Application No: EP/19/22/HH
Site Address: 52 The Roystons East Preston BN16 2TS
Description of works: Single storey rear extension, revised dormer and raised garage roof.

Thank you for your internet representation made on 30th March 2022 which has been recorded as an objection with the comments as follows:

Project: Proposed alterations; 52 The Roystons, East Preston BN16 2TS	
Drawing: Elevations as proposed	
For: Mr. & Mrs. Hicks	
Drawn: PKS	Date: December 2021
Scales: 1:100	No: 2881/01/04
To scale when printed on A3

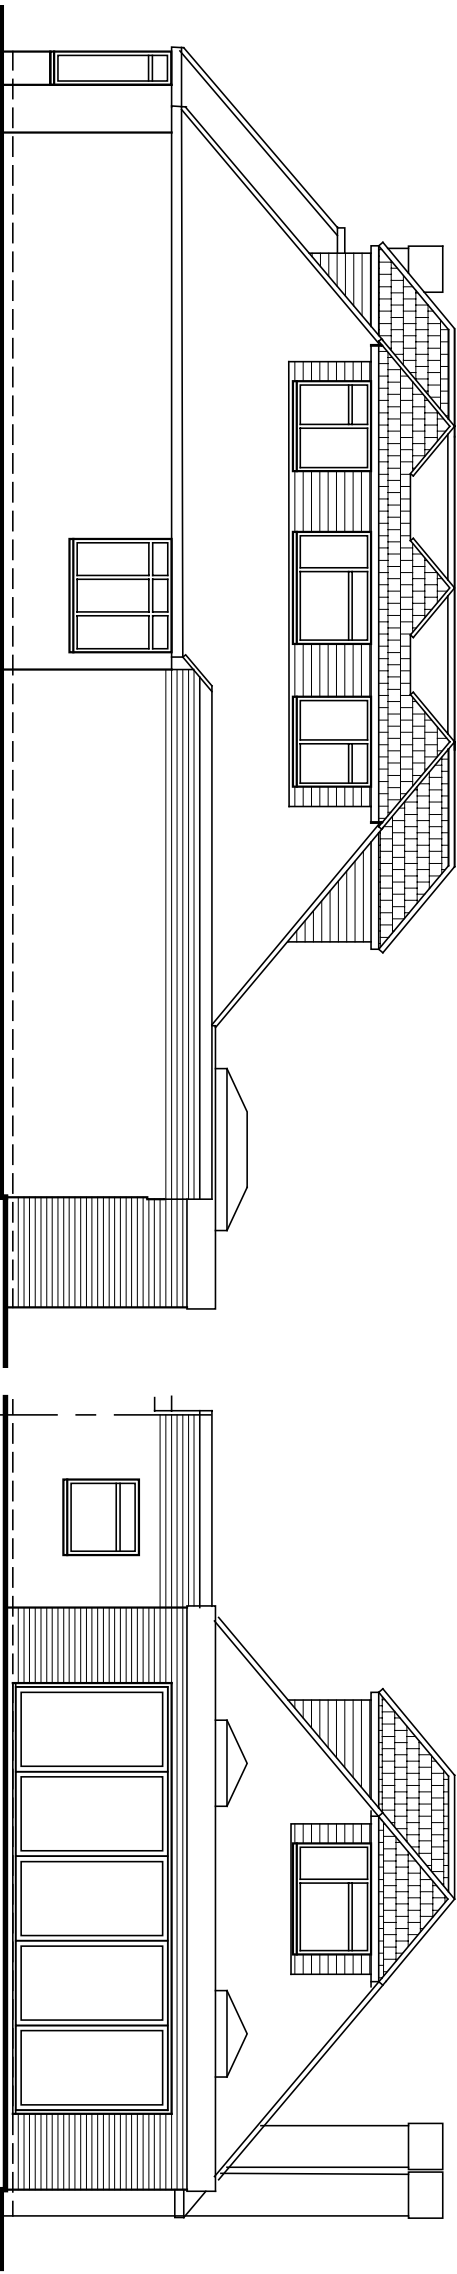
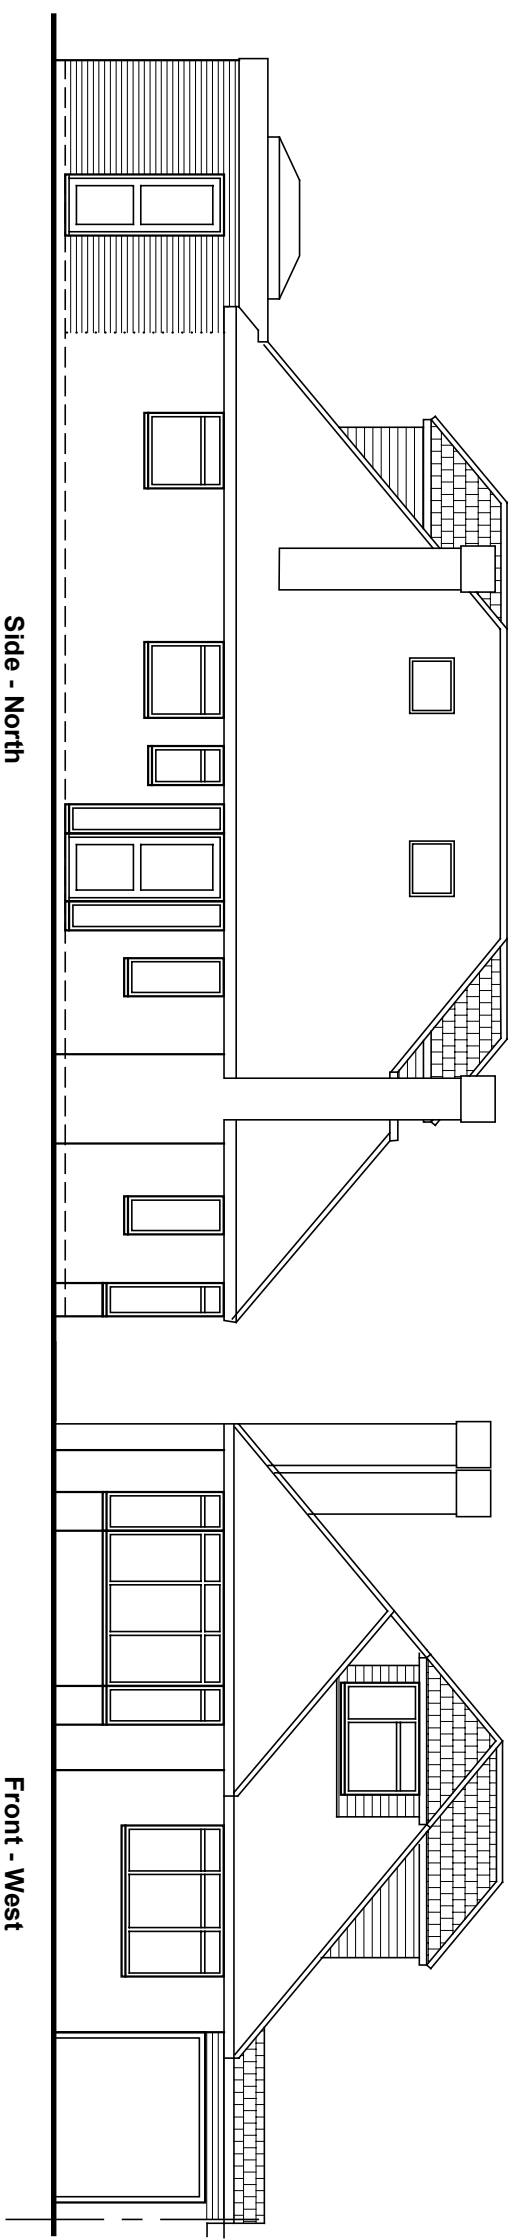
I write on behalf of the East Preston and Kingston Preservation Society, which has no objection to the rear extension nor to the materials proposed. However, the proposed triple-gabled dormer design replacing the present south-facing flat-roofed dormer, whose ridges spring from the ridge level of the main roof, is possibly over-dominant, as is the proposed front dormer, for the same reason, as it extends the line of the ridge in a manner uncharacteristic of most houses in this close of bungalows. Lower dormer ridges would be acceptable.

We are also concerned that the increase in the height of the garage roof will mean that it no longer links satisfactorily with the adjoining garage and would disturb the symmetry of this attractive pair of bungalows. For these reasons the Society asks that this application be refused unless the plans are amended.
